Application for a non-material amendment following a grant of planning permission.
Town and Country Planning Act 1990

House:		Suffix:	
House name:	Badgers		
Street address:	Ham Manor Way		
Town/City:	ANGMERING		
Postcode:	BN16 4JQ

first floor side extensionm

first floor window added to South elevation

GROUND FLOOR
PROPOSED FLOOR PLANS 1:50

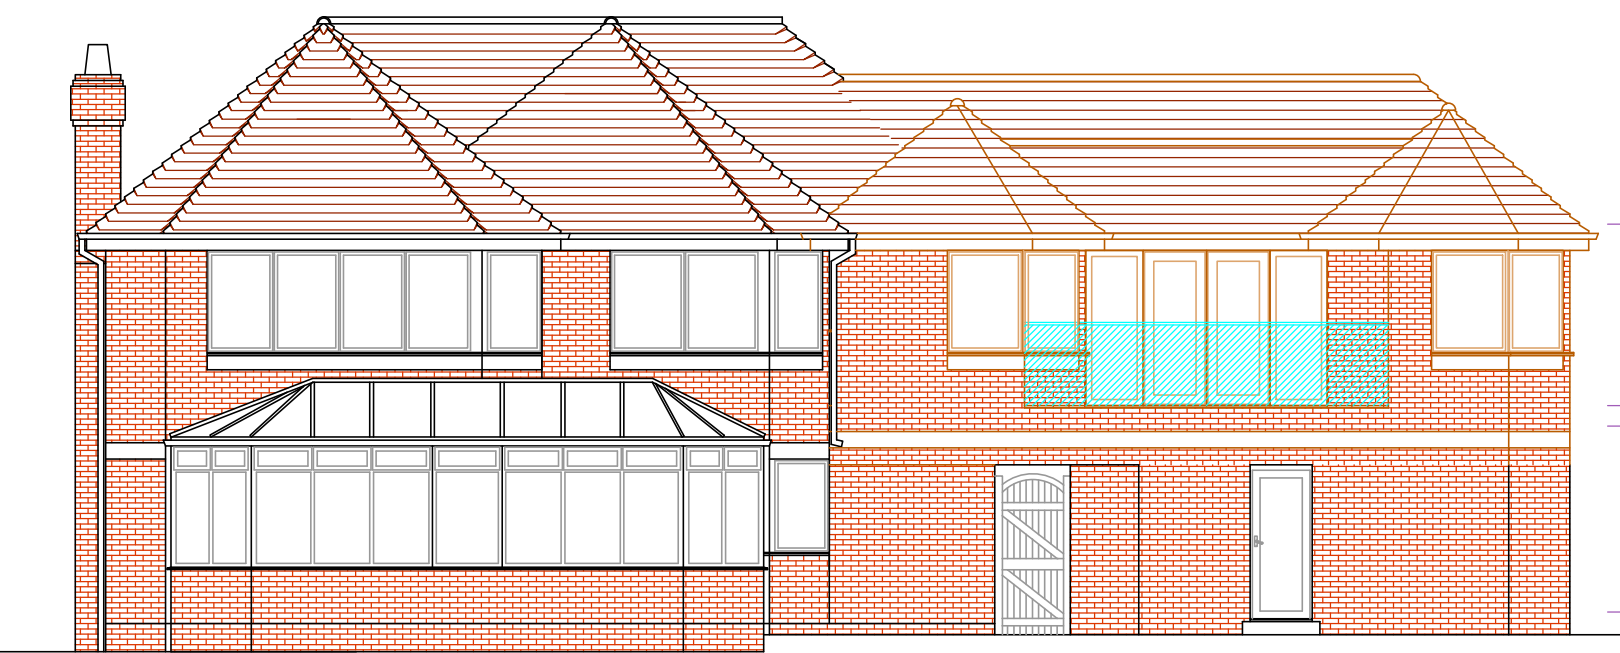
This plan was issued to Planning but not included in Application drawings. Client design change - required additional window

17027/02 R3
